Application no: **3/2023/0599**

Address: **Lower Edge Farm Tinklers Lane Slaidburn BB7 4TP**

Proposal: **Erection of an agricultural building and revised gate access.**

S.J. Bialecki Building Surveyors
Drawing no 5004
Scale 1:200
Proposed Agricultural Building On Land At Lower Edge Farm Tinklers Lane Staidburn

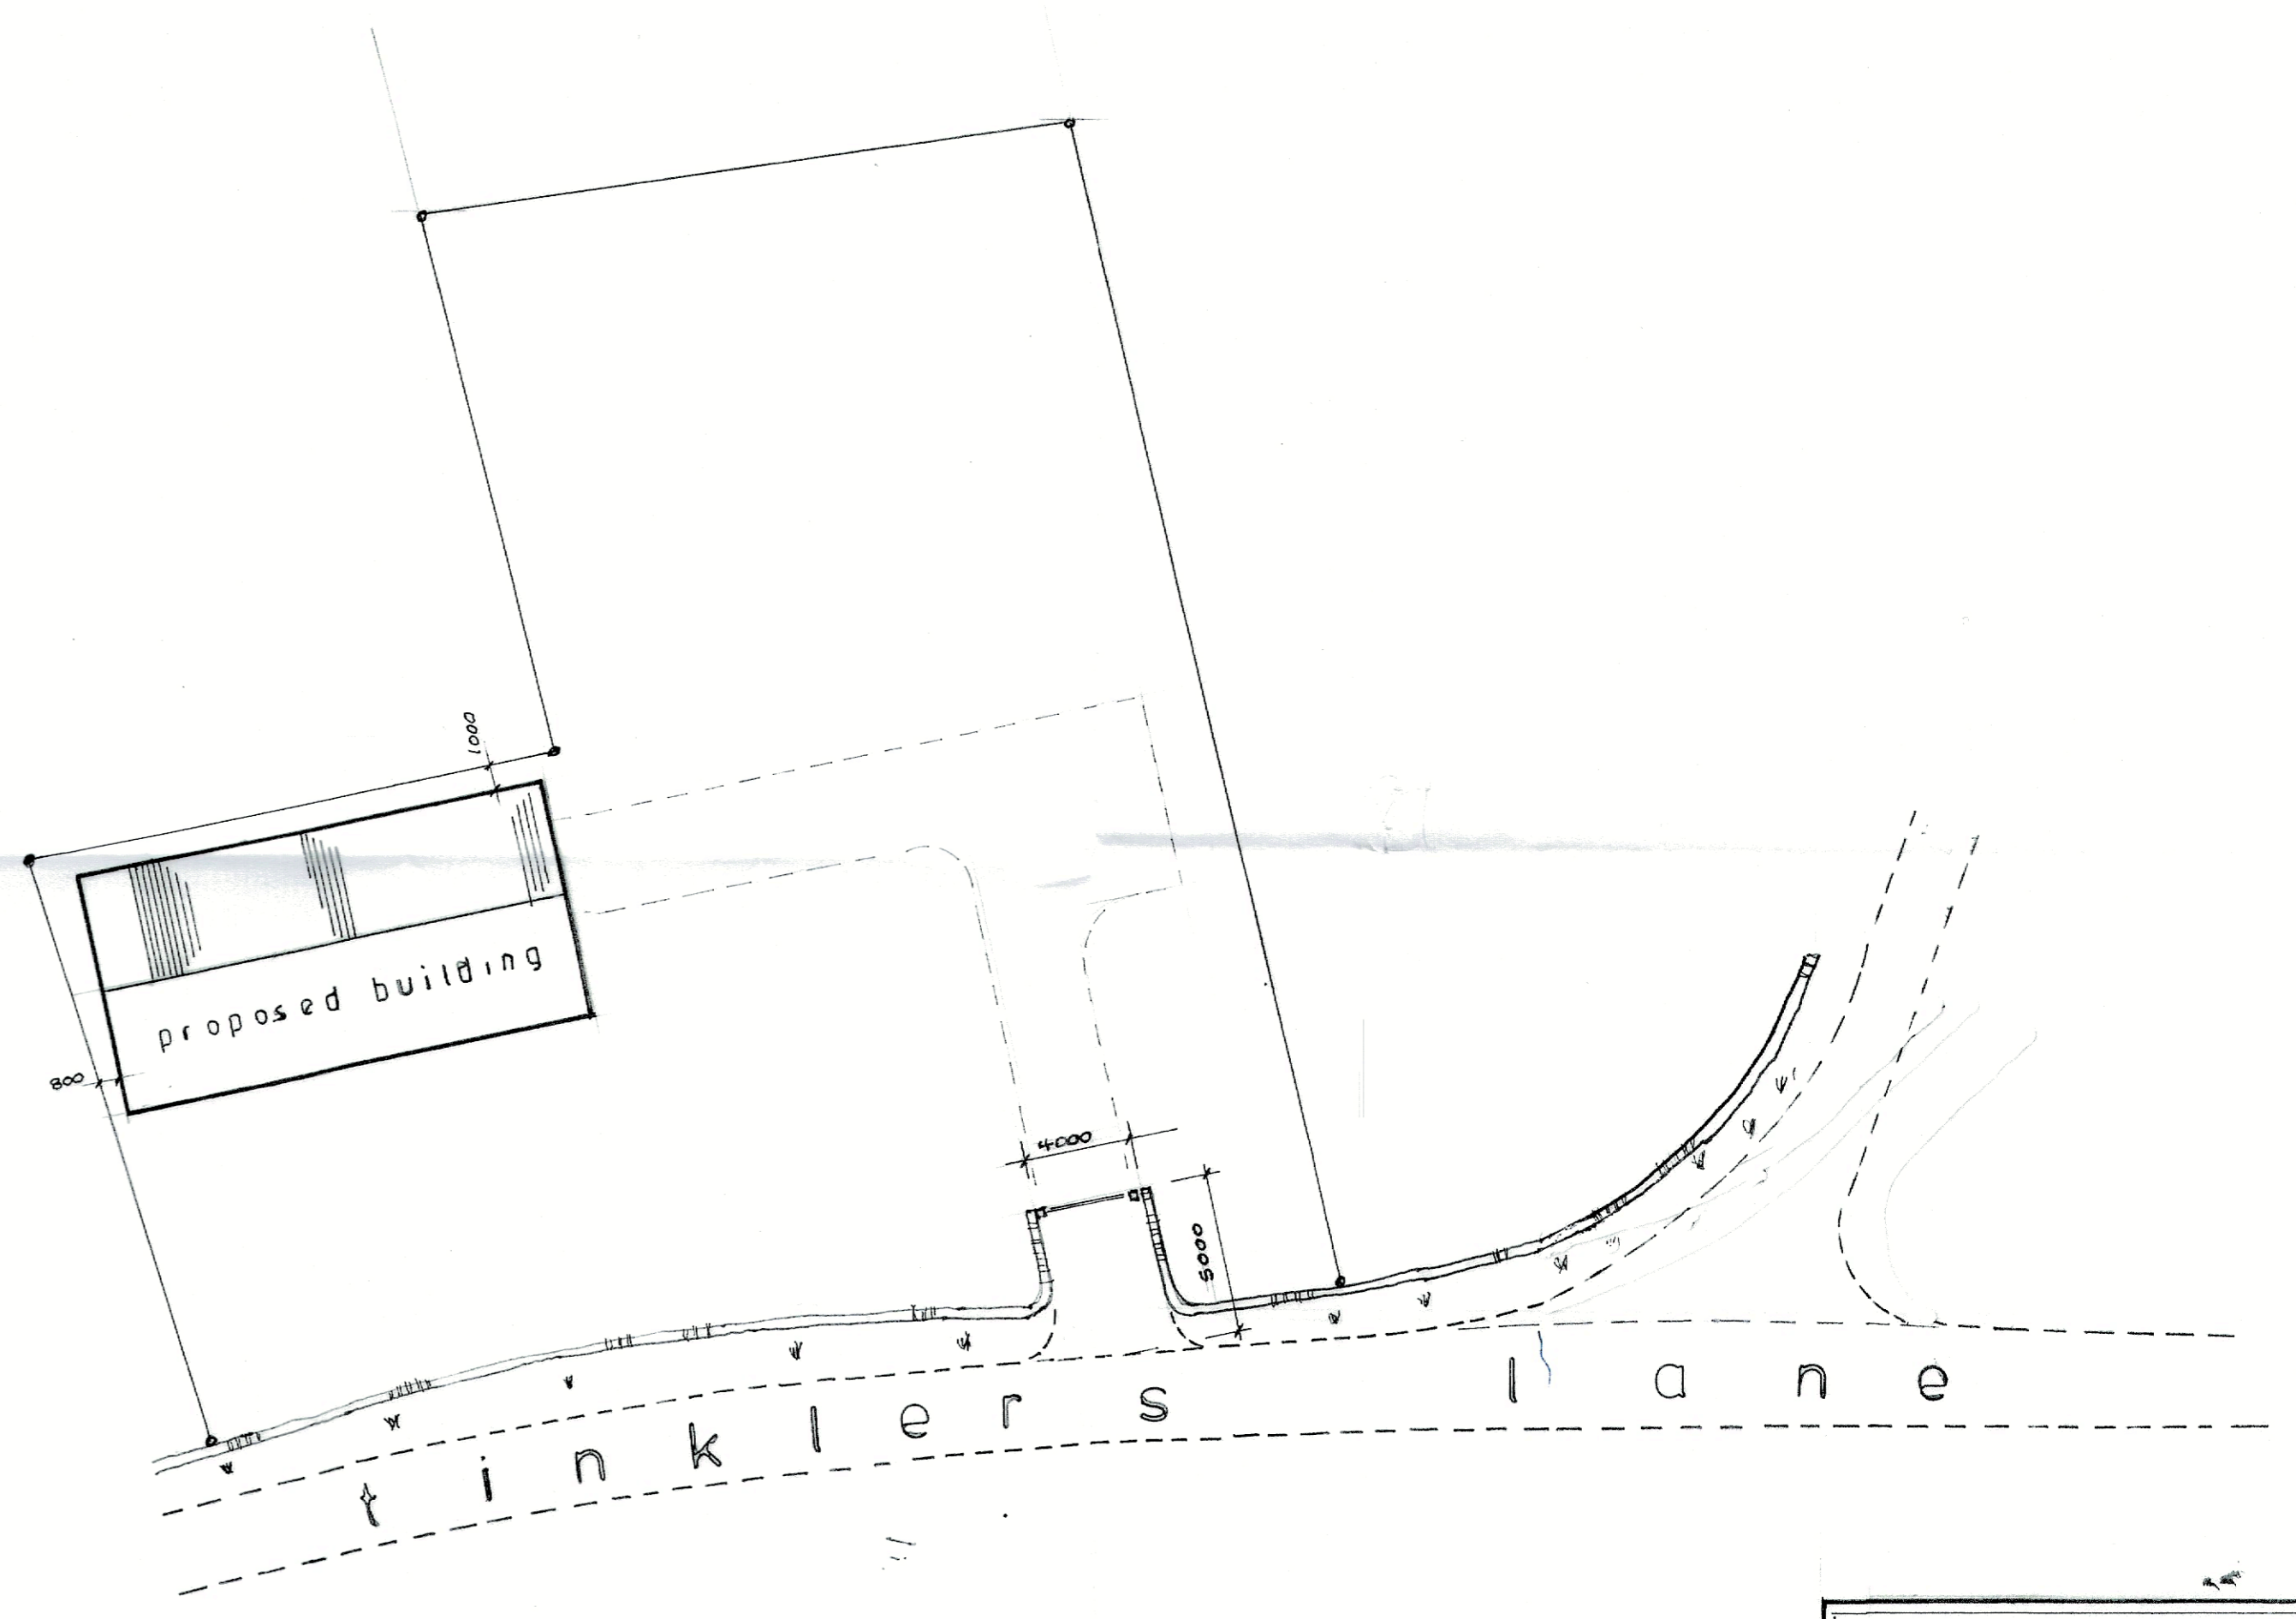
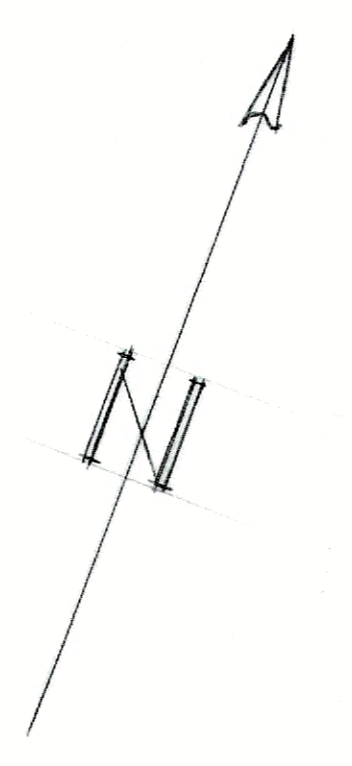
The LHA have reviewed SJ Bialecki drawing number 5004 and are aware that the proposal will continue to utilise an existing agricultural access located off Tinklers Lane which is a C classified road subject to a 60mph speed limit.

The LHA have reviewed the access and have no comments to make given that the access is existing and is already used to access the agricultural field.

However, the LHA will request that the gate is setback 6m from the public highway to ensure that agricultural vehicles using the access do not block the public highway to operate the gate and surfacing improvements are made.

1. Notwithstanding the provisions of Part 2 of Schedule 2, Article 3 of the Town and Country Planning (General Permitted Development) (England) Order 2015 (or any Order revoking and re-enacting that Order) no vehicular access gates, barriers, bollards, chains or other such obstructions shall be erected within a distance of 6 metres of the highway boundary, nor shall any be erected within a distance of 6 metres of the highway boundary unless hung to open away from the highway.

2. The development hereby permitted shall not be occupied until such time as the access drive (and any turning space) has been surfaced with tarmacadam, or similar hard bound material (not loose aggregate) for a distance of at least 6 metres behind the highway boundary and, once provided, shall be so maintained in perpetuity.
